From: Sue Howell
Sent: 28 February 2019 14:49
To: Planning.Responses
Cc: Michael Eastham
Subject: FW: Planning Consultation on WA/99/18/DOC

Further to submission of revised landscape details contained in dwgs CSA 3823-101-111 Rev B in relation to Condition 9 of this application WA/99/18/DOC I can recommend the following:

APPLICATION NO: WA/99/18/DOC

Site Address: Land East of Tye Lane Walberton Arun

Do not scale from this drawing. Refer to figured dimensions only.
Drawings are produced for planning purposes and are not a construction issue.

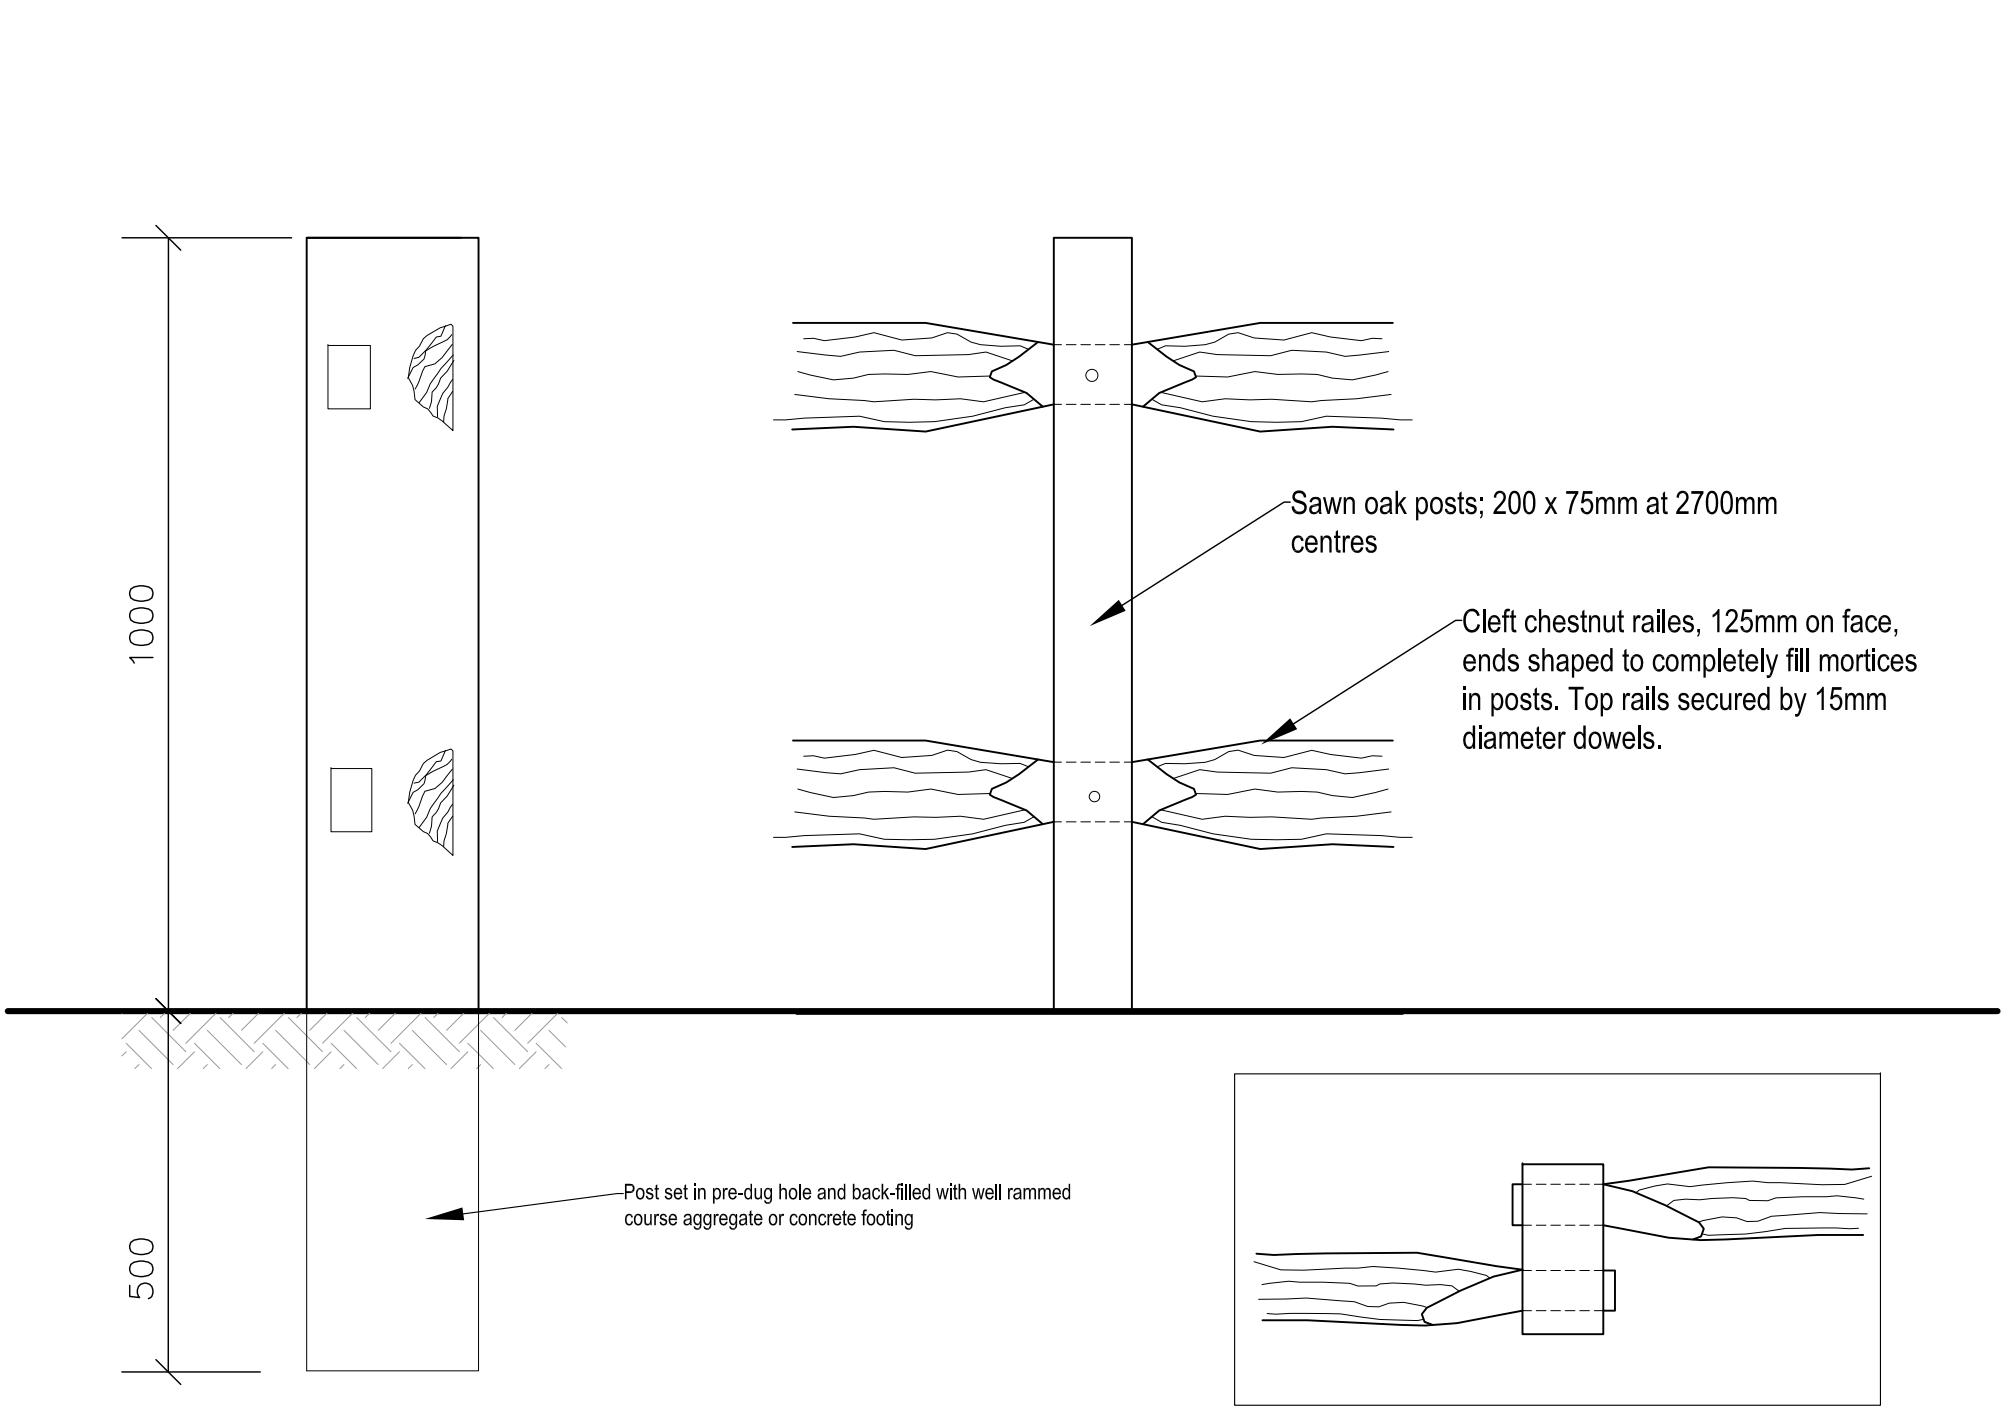
- II. Details re height, design and type of boundary treatment have been provided.
- III. Crown spread and location of trees to be retained have been shown in location within masterplan and detailed landscape drawings and the topography in which these sit.

I would therefore **recommend discharge of Condition 9** landscape details contained in this reserved matters application WA/95/18/RES following outline consent WA/44/17/OUT.
